PLANNING AMENDMENT

H11/07772/97

Proposed NEW BUILDING

Amendment: Polytunnel added (drawing no. 3A)

BLOCK PLAN

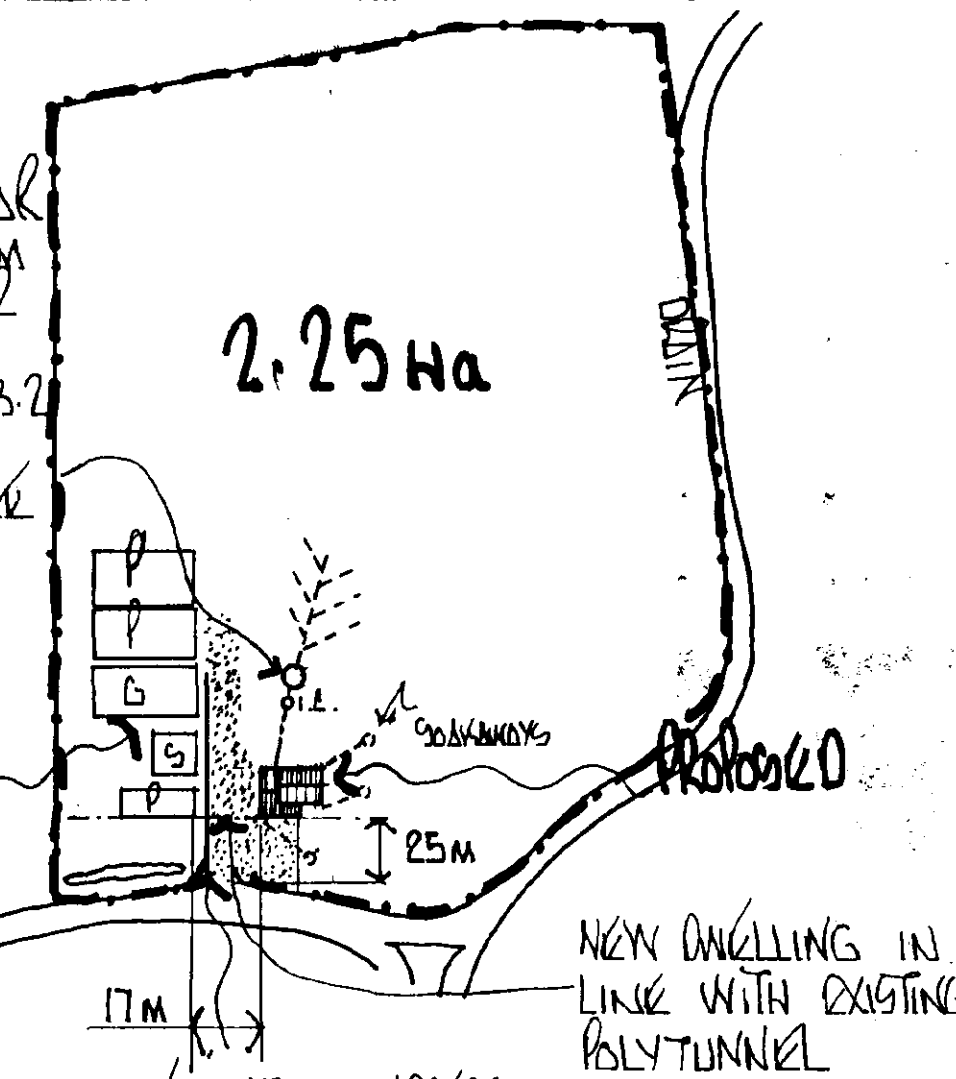
POLYTUNNEL ADDED
TO BLOCK PLAN
